From: Bloomer, David <David.Bloomer@lancashire.gov.uk>
Sent: 28 June 2017 14:44
To: Rebecca Halliwell
Cc: LHS Customer Service; planning
Subject: app3/2017/0513 16 Sutherland Close, Wilpshire

TRI-JS01-01

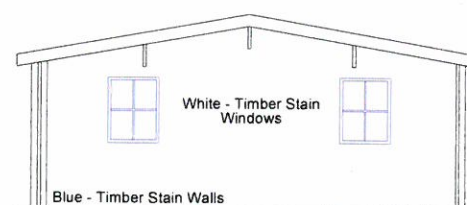
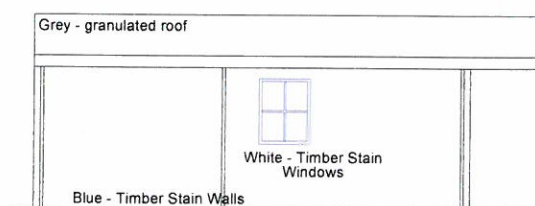
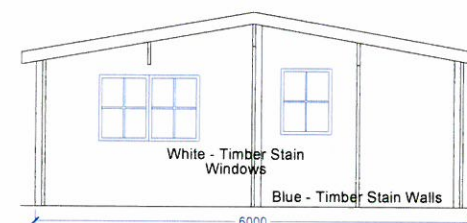
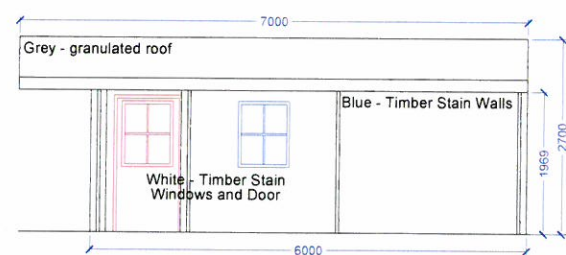
Whilst I would raise no objection to the proposal as it is described as being ancillary to the main dwelling I am mindful that should the applicant subsequently request removal of this ancillary tie then the property would not benefit from an independent parking facility and with the proposed layout it is doubtful if any parking could be provided retrospectively.
